WALSH BAY ARTS AND CULTURAL PRECINCT

RESPONSE TO SUBMISSIONS

TZG RESPONSE TO CITY OF SYDNEY SUBMISSION

CITY OF SYDNEY

1 WHARF 4.5 EAST ELEVATION - DEMOLITION + CONSERVATION

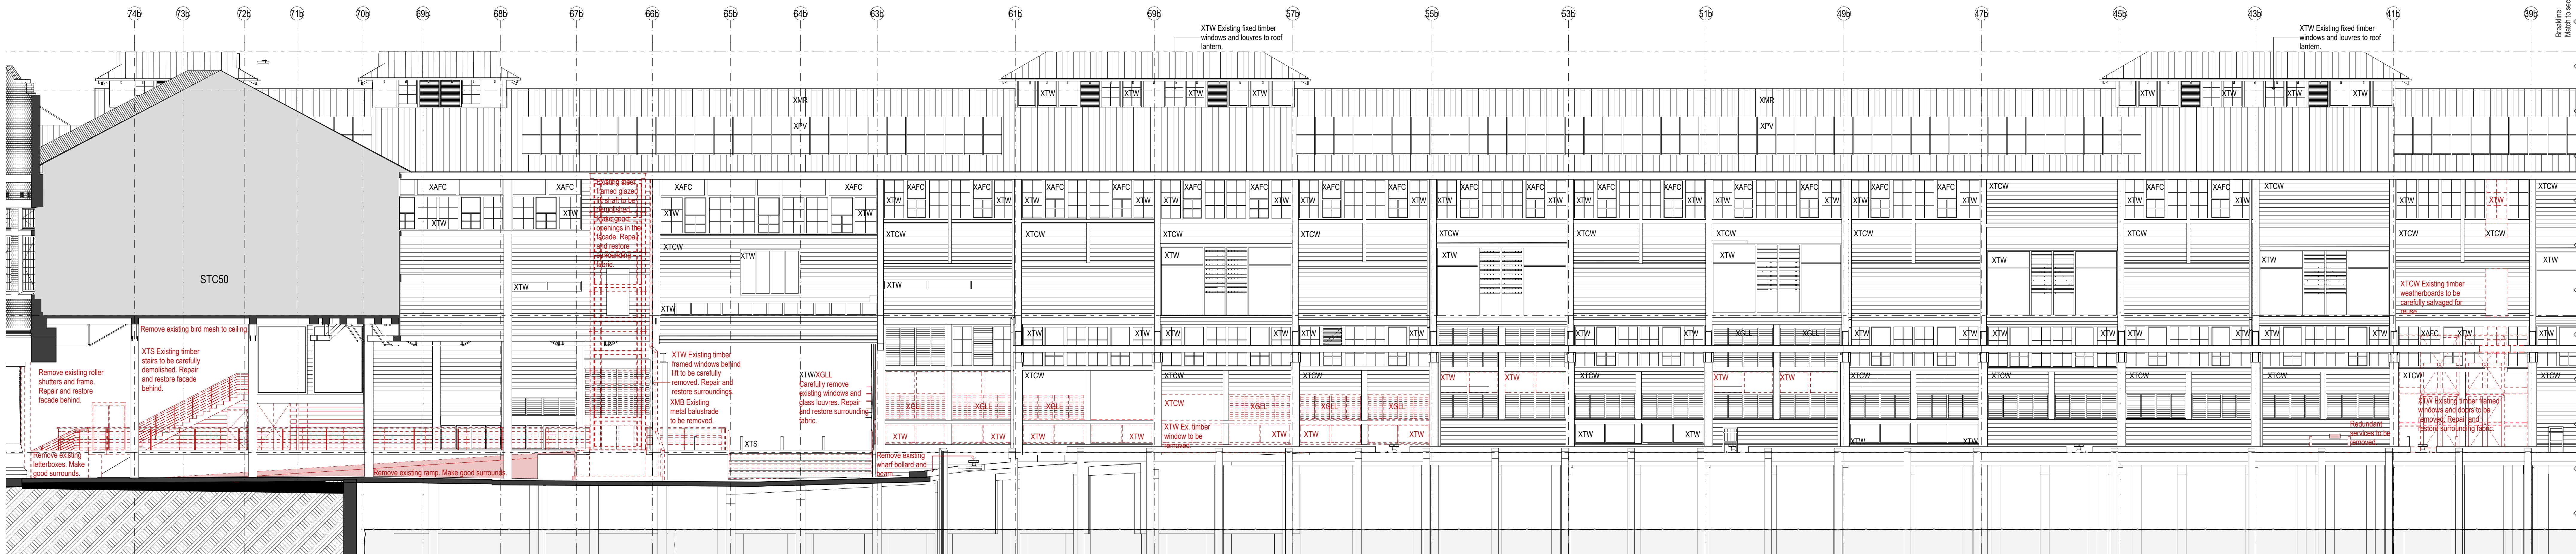
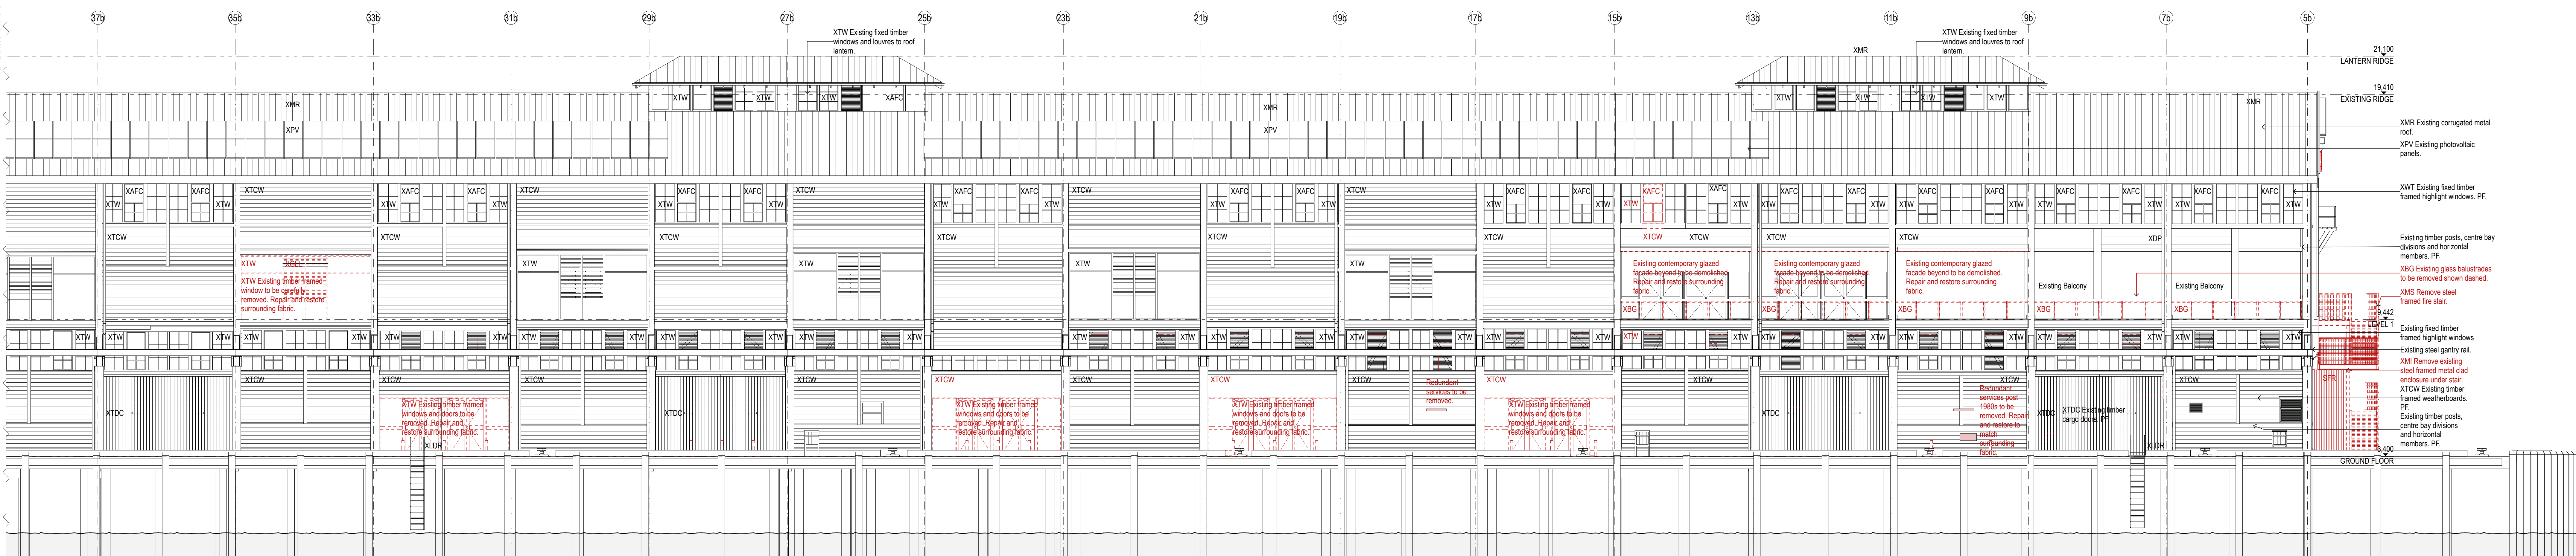
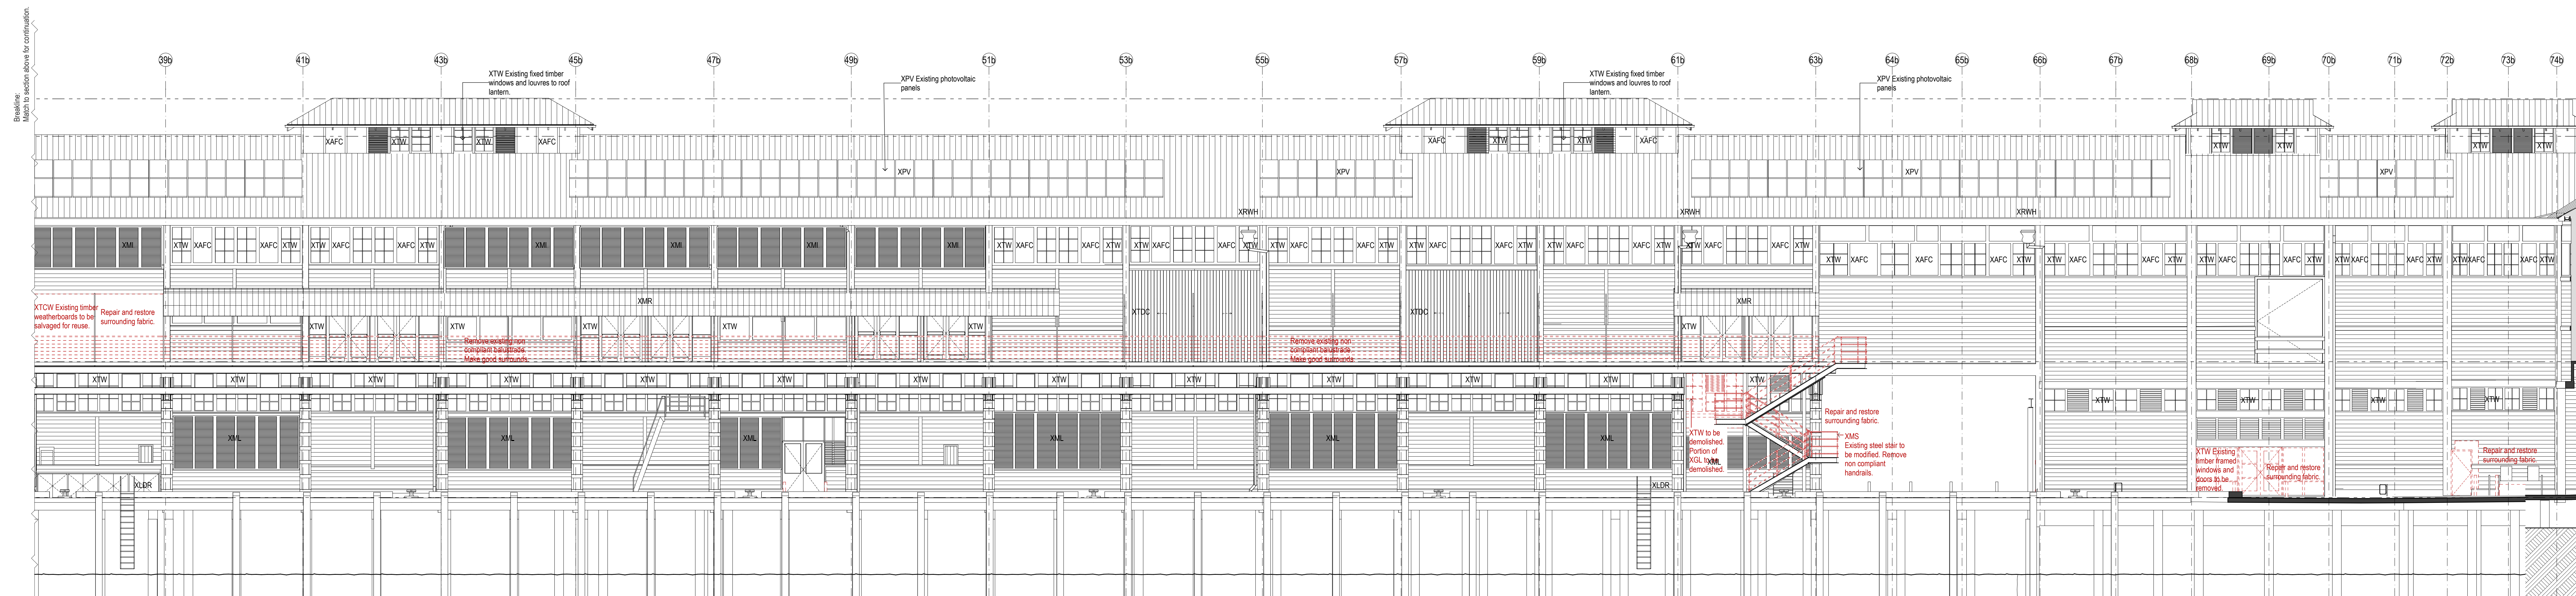
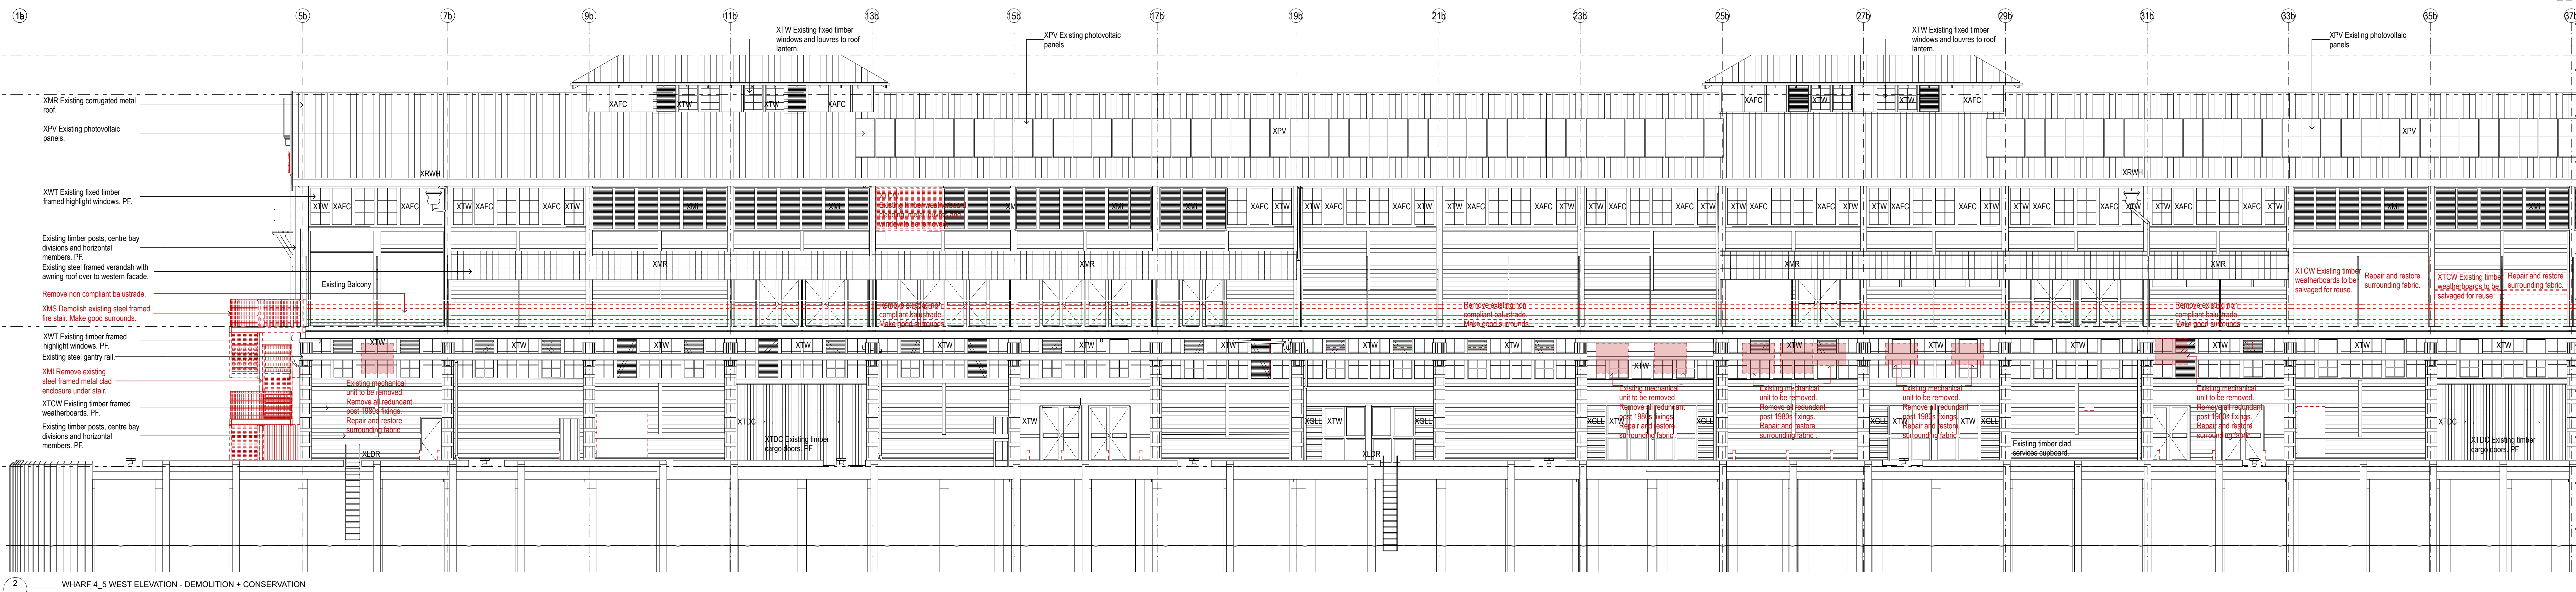
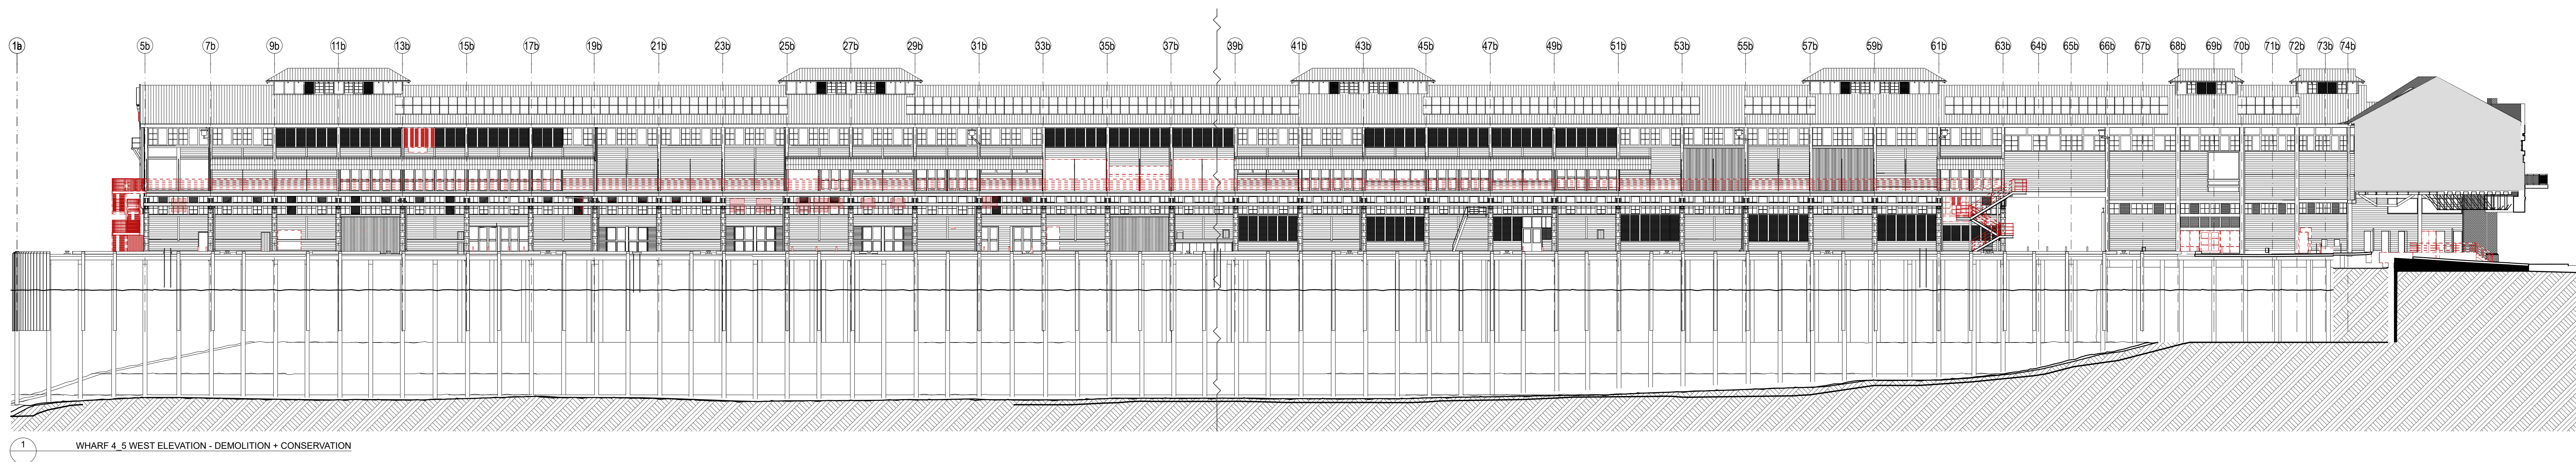
City of Sydney Comment - 1 a)
Concern is raised regarding the height of the proposed external lifts and their visual prominence from key vistas when viewed from Sydney Harbour, particularly at the northern end of Pier 2/3. Consideration should be given to a reduction in height of the lift over-runs and locating these lift shafts further south along each elevation. It is also recommended that lift shafts and balconies are aligned symmetrically on the eastern and western elevations of the wharf buildings.

Response
A sympathetic and modest design approach has been adopted for all external additions to ensure that they respect the industrial character of the wharves and to minimise their visual prominence. A similar architectural language is proposed for the new lifts, stairs and gantries for both Wharf 4/5 and Pier 2/3 to clearly distinguish new elements from original fabric, to unify the composition and ensure visual consistency across the precinct.

Locating four of the lifts external to the building minimises the impact on interior significant fabric. Their impact on the exterior has been minimised by designing them as contemporary steel framed glazed elements that are as transparent as possible and reversible.

The external lifts are set back from the wharf edge by a minimum of two structural piling bays in accordance with Policy 9.6.5 of the Pier 2/3 CMP and positioned to relate to the internal uses they serve.

Internal functional constraints, related to the demanding requirements of access and egress to the performance venues, means that

it is not possible to move the lift shafts further south along the elevations or to align the lifts symmetrically on the eastern and western elevations of the wharf buildings. The internal planning itself has been strategically designed to minimise loss of heritage fabric.

The lift shafts have been designed to be as small as possible to provide equitable access and efficient goods movement within the Precinct. The height of the overall lift shaft structures has been carefully considered in terms of overrun, relationships to the original buildings and consistency within the Precinct.
